City of Albuquerque Stormwater Construction Site Inspection Report

ESC File No.	M10E020	Project Name:	Kidz Academy and The Human Bean		
NPDES Id. No.	NMR1003NO/NMR1003NP	Location:	7800 Sage Rd. SW		
7/29/2021	Owner	Contractor			
Operator	Kidz Academy Preschool Lader Real Estate, LLC	Creative Design Builders			
Contact name & title	Keith Griego	Raymond Herrera			
e-mail	kidzacademystaff@gmail.com	rhcdb46@yahoo.com			
Contact Phone #	505-681-7812	505-410-9020			
COA Inspector	Doug Hughes	Start/End Time:	10am		
Construction Phase:	Vertical				
Type of Inspection:	Regular	Storm Event	Past Storm Event >0.25"	311/Complaint	Follow Up
Weather at time of inspection?		clear	Temperature:	~	91
Estimated date of last storm 0.25" or greater		7/23/2021

TEMPORARY EROSION AND SEDIMENT CONTROL PLAN

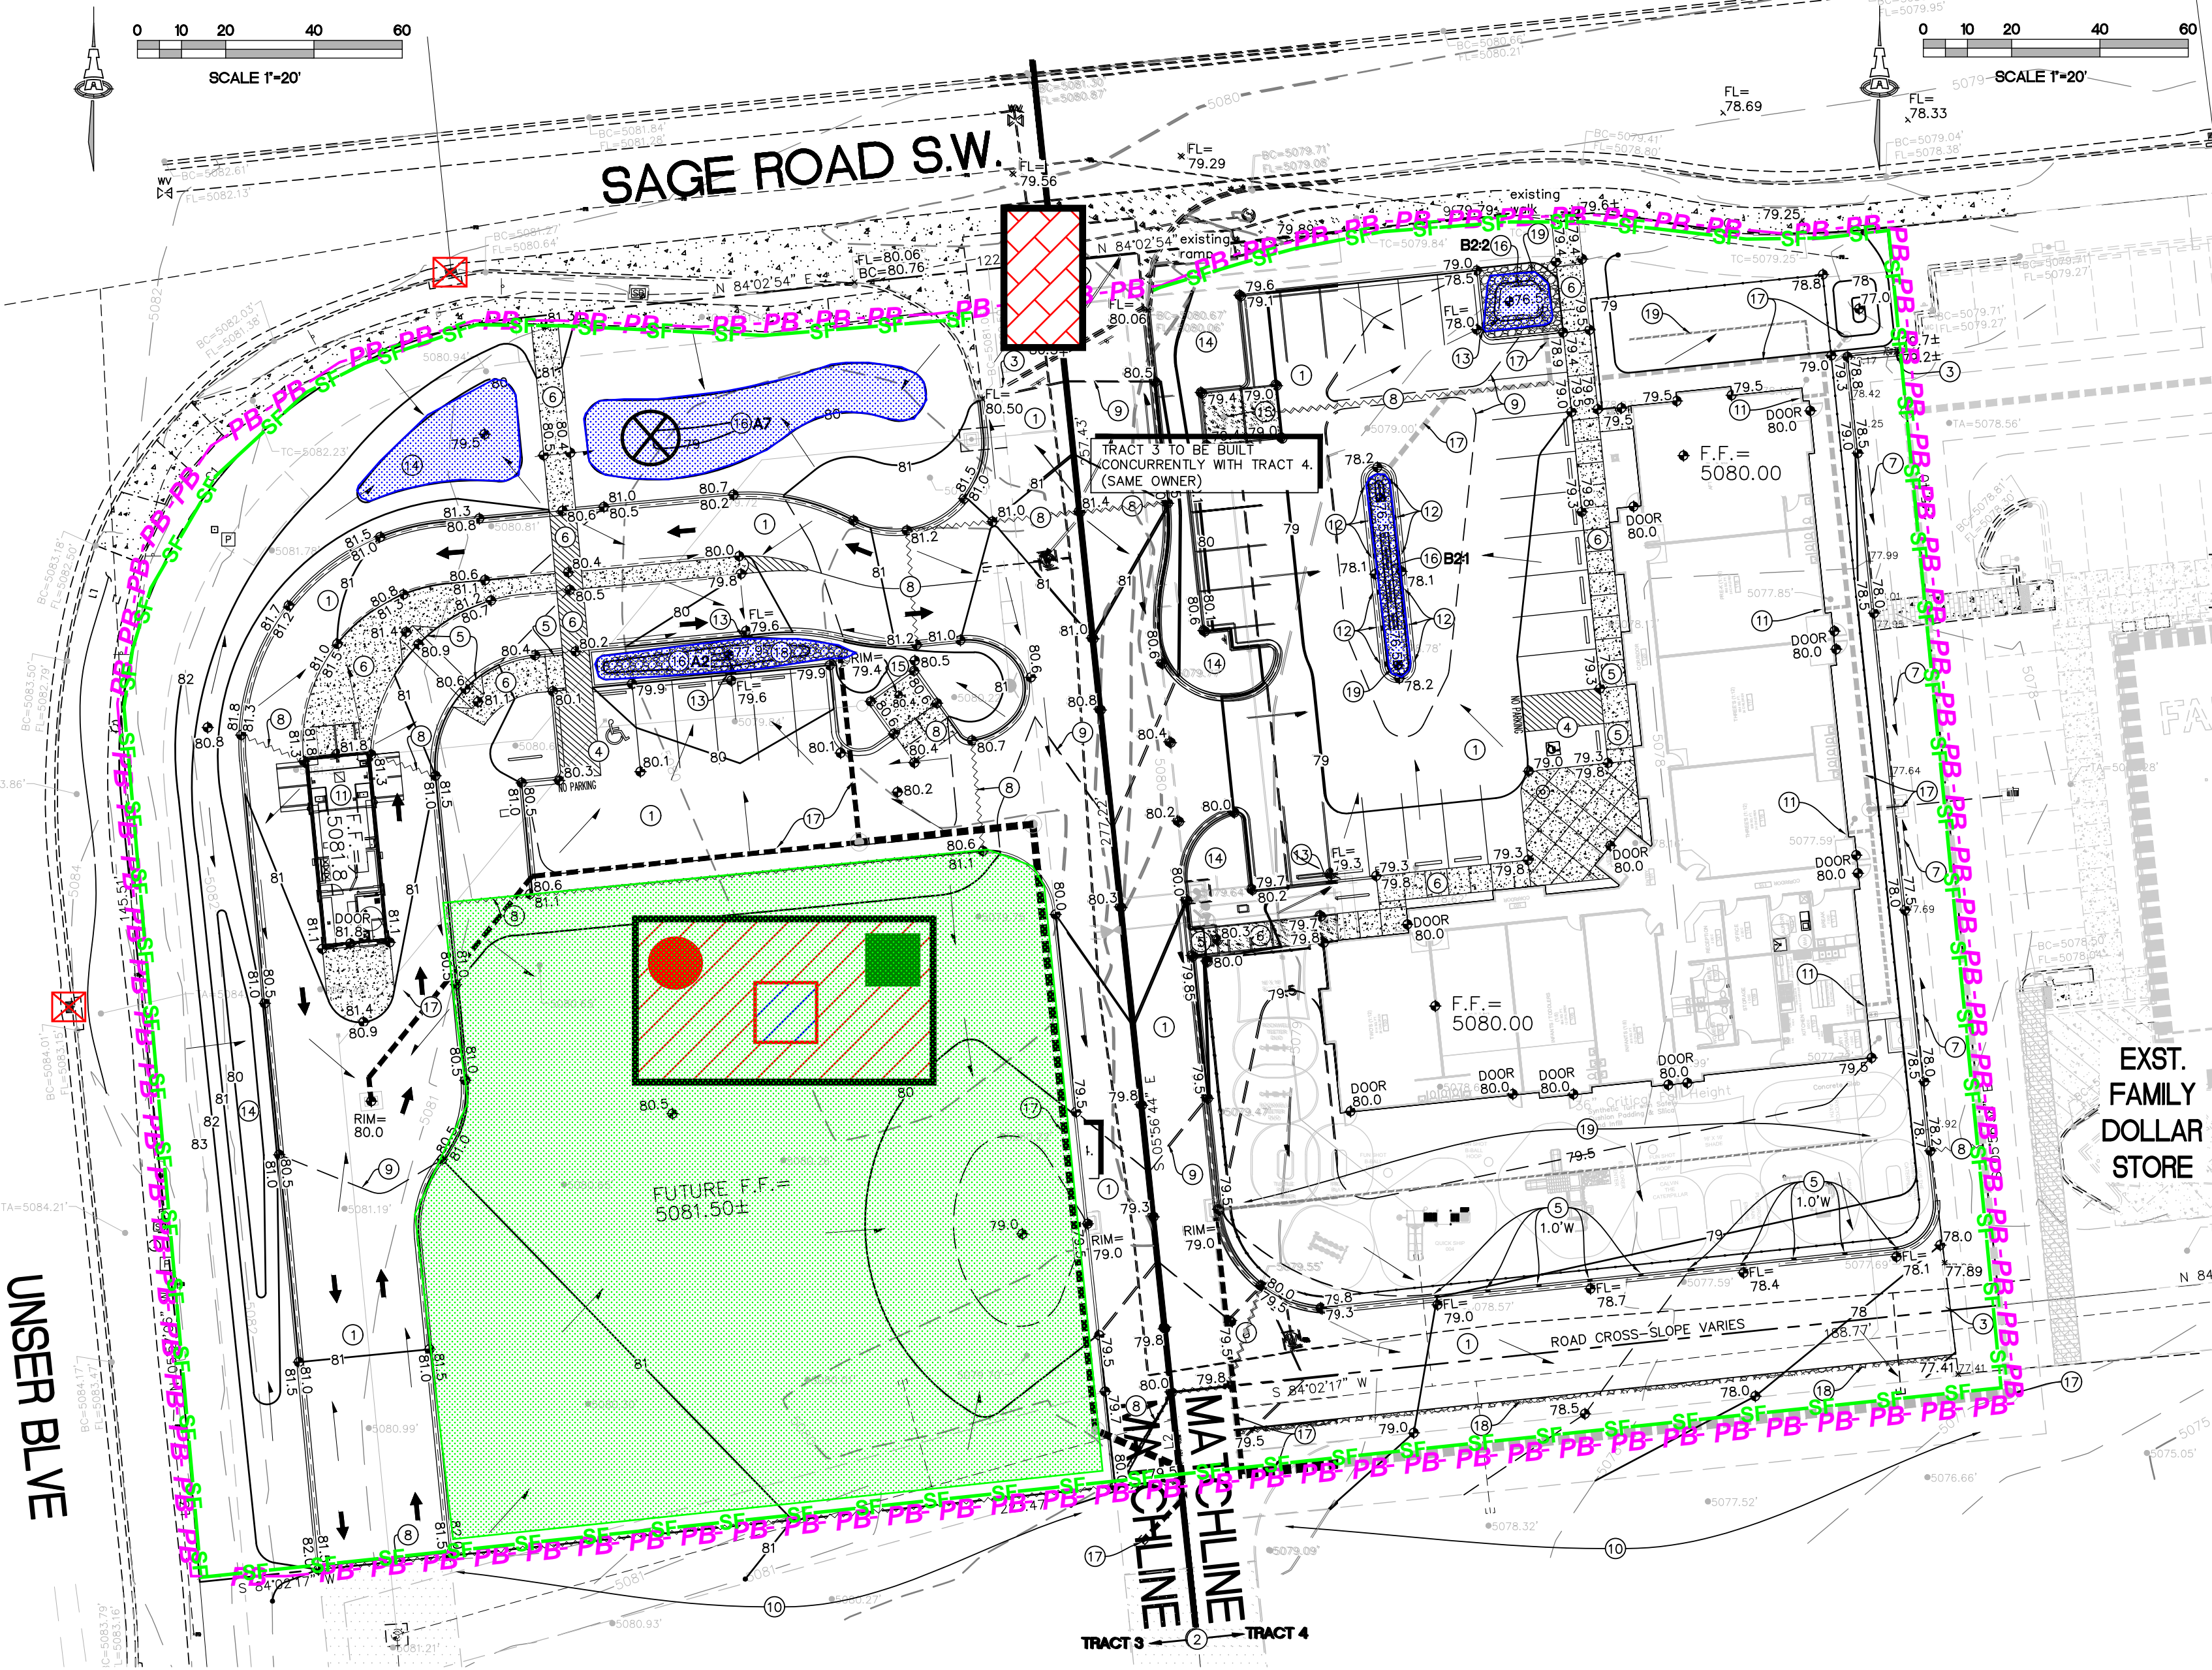
Item Number	Deficiency/ Corrective Action				
1	Construction/domestic waste on ground and dumpster full and overflowing. Place construction/domestic waste in an approved waste container per CGP .				
2	Inlet Protection in Unser west of this site is not maintained and is not needed since the site doesn't drain there.				
3	SWPPP deficiencies - 1) Reports not signed by Operators or Delegated Authority 2)swq team not per CGP 6.1				
4	Stabilization, west half of site inactive and not stabilized per CGP 2.2.14. Which Owner is responsible?				
5	Self Inspection Report inaccurate. It talks about problems with siltfence at stock pile but says no corrections needed at the end. It makes no mention of full dumpster and waste on the ground.				
6	Minor washout west of building, and no washout facility onsite.
